# CITY OF ALBUQUERQUE

**RE: Warehouse, 4455 Anaheim  
Grading and Drainage Plan  
Engineer's Stamp Date 5-13-2015 (File: C17-D123)**

Based upon the information provided in your submittal received 5-14-15, the above referenced plan cannot be approved for Building Permit until the following comments are addressed:

ENGINEER'S SEAL	4455 ANAHEIM NE	DRAWN BY WCWJ
	GRADING AND DRAINAGE PLAN Rio Grande Engineering 1606 CENTRAL AVENUE SE SUITE 201 ALBUQUERQUE, NM 87106 (505) 872-0999	DATE 5-13-15
		SHEET # —
		JOB # 21515

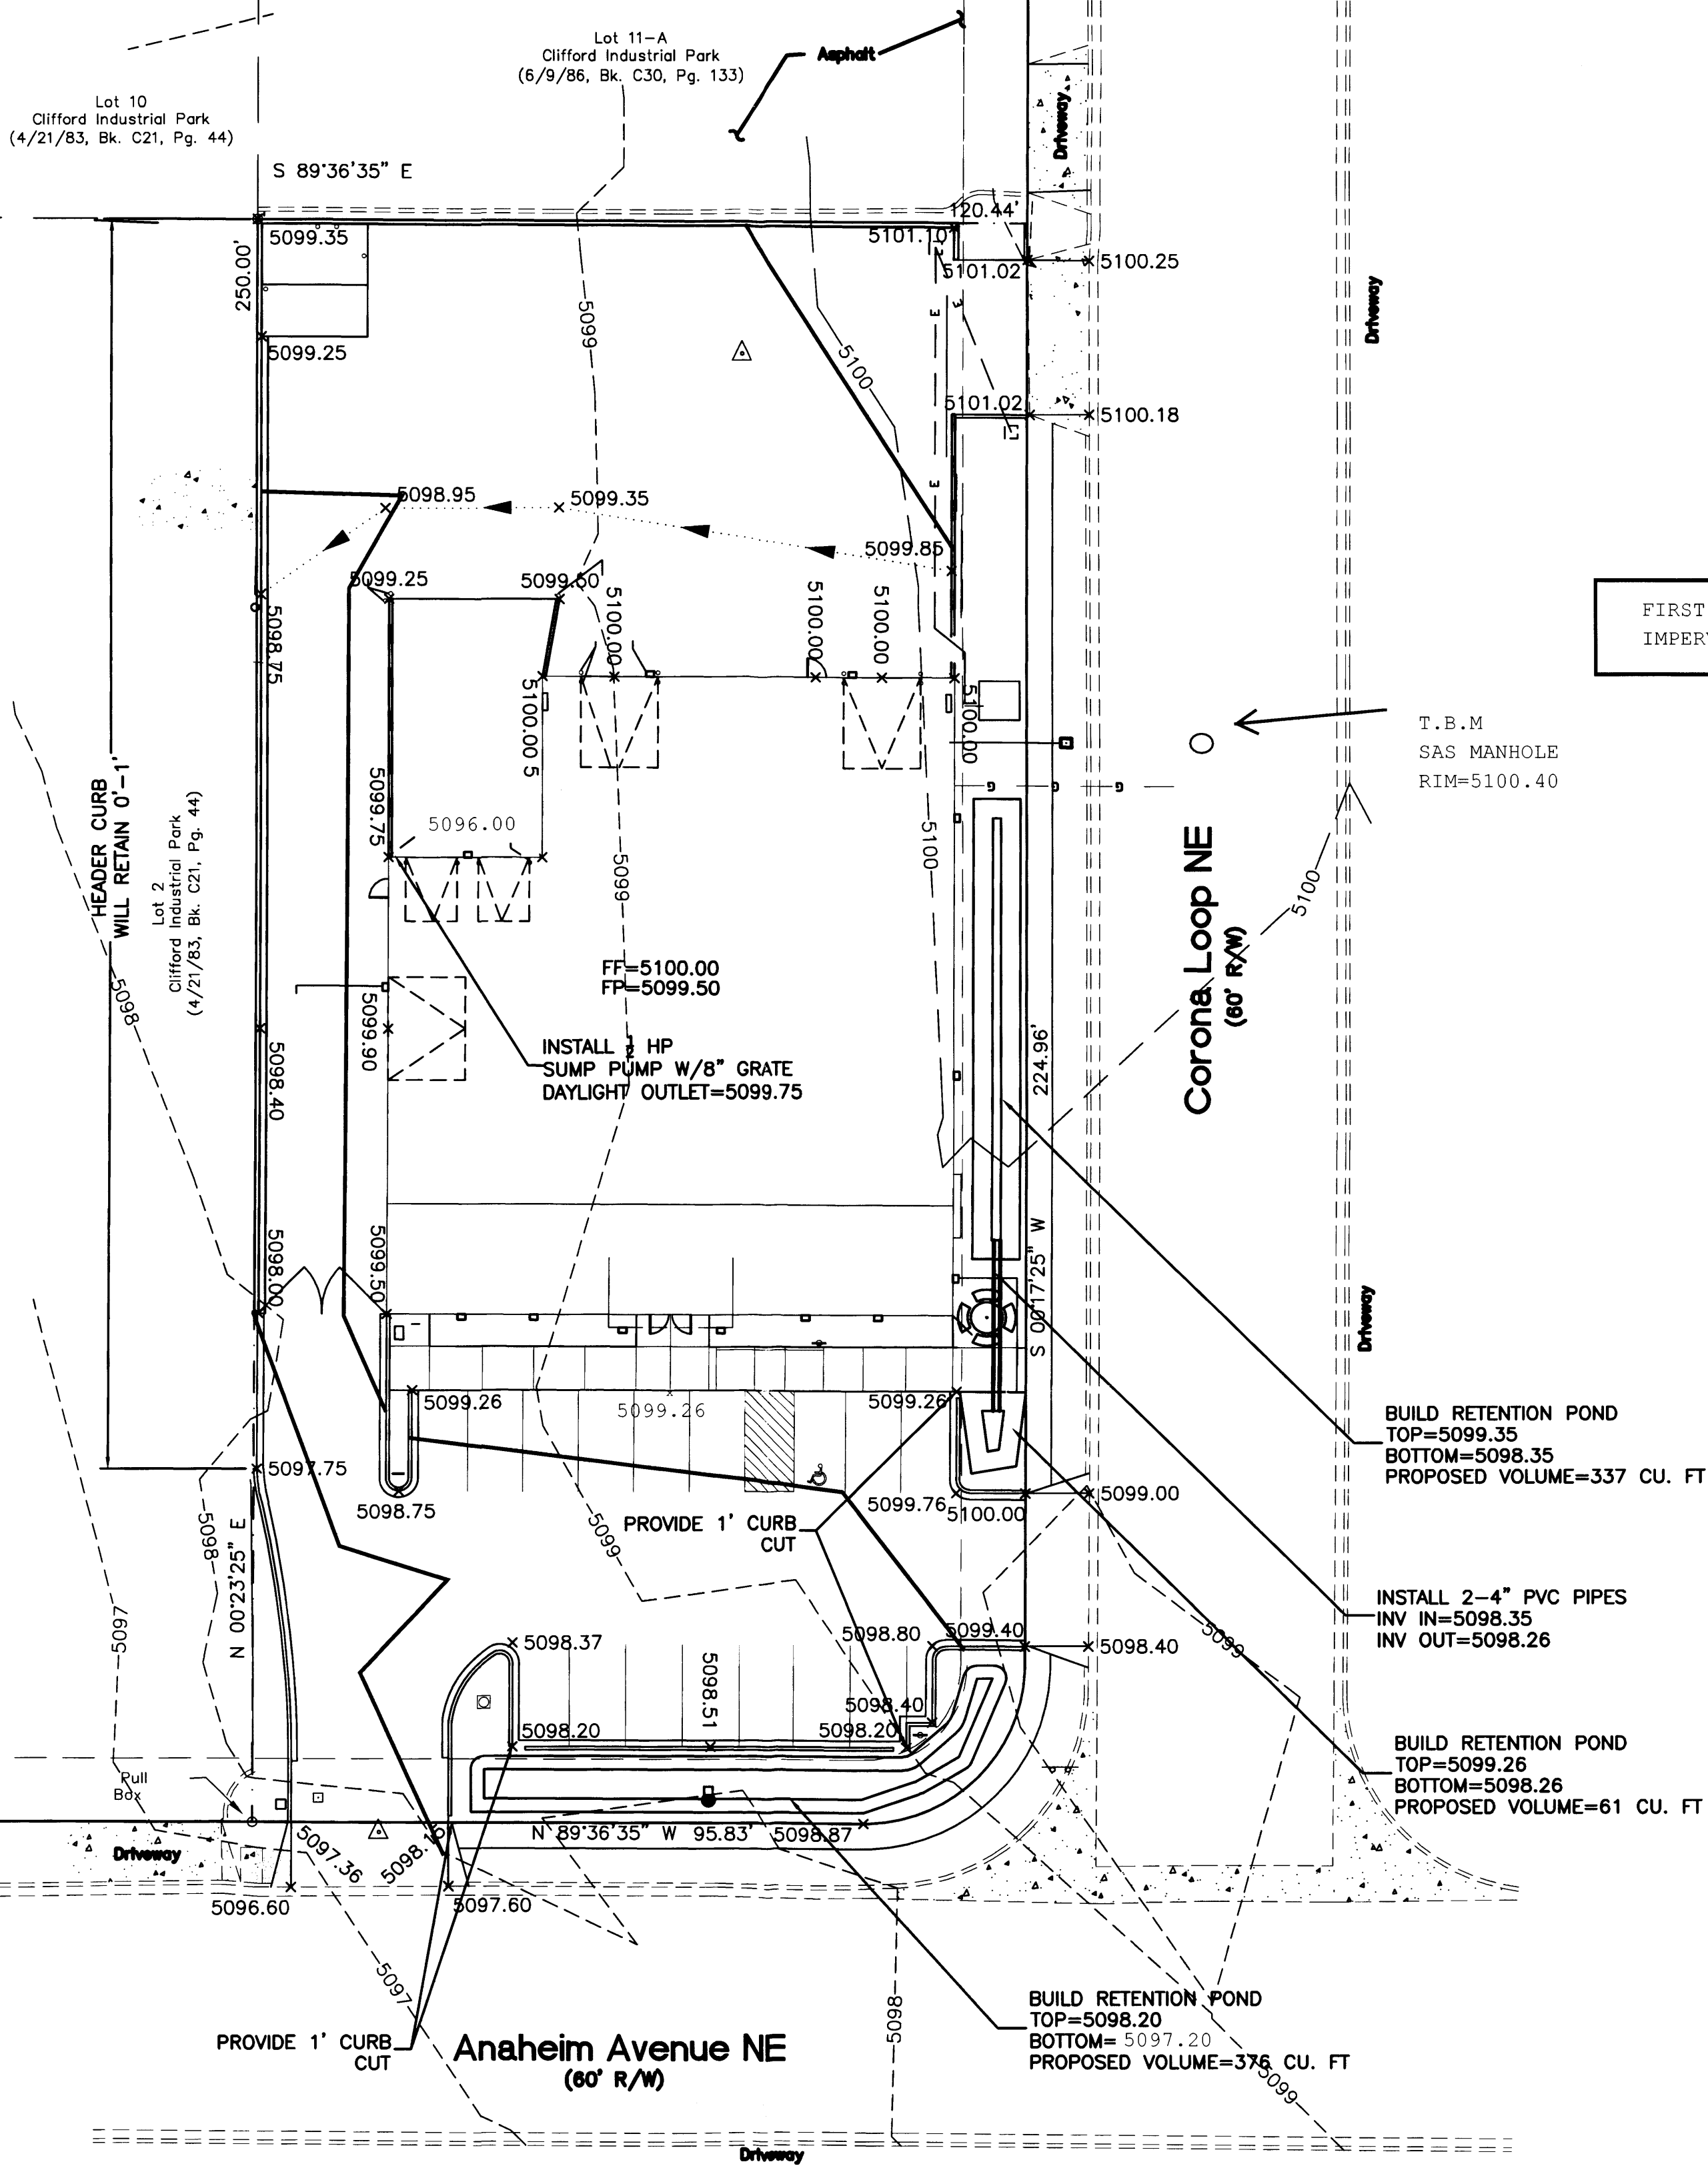
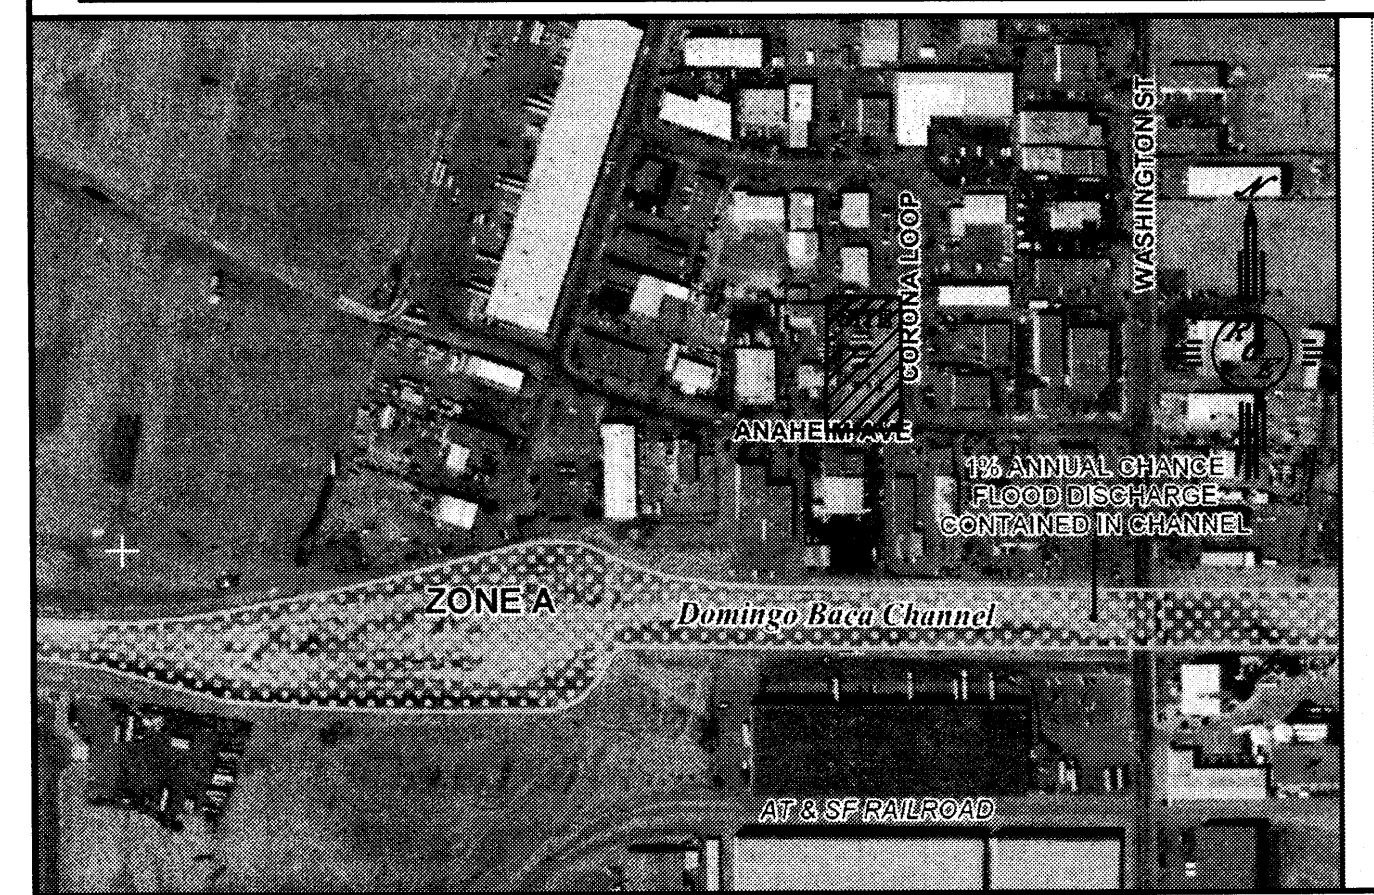
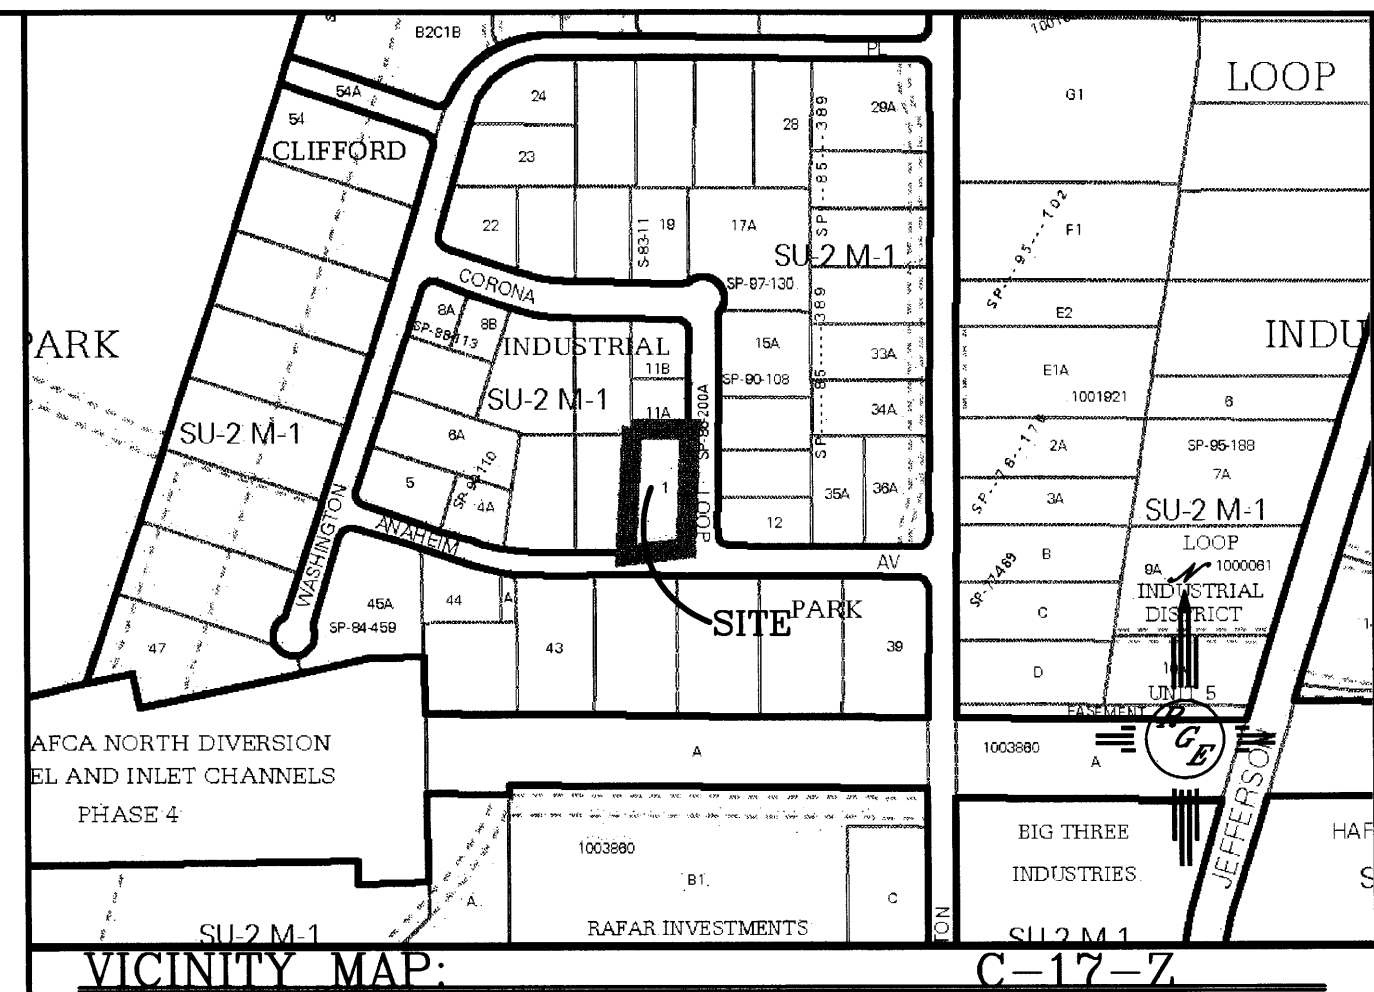
- 1) Provide new and existing curb linetypes and building boundary within legend. Label any gravel areas as "gravel" and paved areas as "paved", and count gravel lot areas as land treatment type "C". Label any new curb and curb height on the plan view as applicable.
- 2) Show roof drain locations.
- 3) Show existing spot elevations for curb on Corona Loop and on Anaheim Avenue. Label proposed contours, and additionally provide boundary lines around each of the pond areas that define the top and bottom elevations of the pond. For the three retention ponds, indicate that they are for the "first flush" if this is the case. If new spot elevations provided are at flowline of curb, provide general note stating this.
- 4) Correct minor discrepancy in the drainage report which shows a discharge of 2.93 cfs under "Proposed Conditions" discussion and 2.36 cfs under "Summary and Recommendations".

- 5) For existing conditions analysis, it is recommended to analyze the parking lot as "C" land treatment as a compacted lot. This results in less of a difference shown for proposed discharge of the site versus existing discharge.
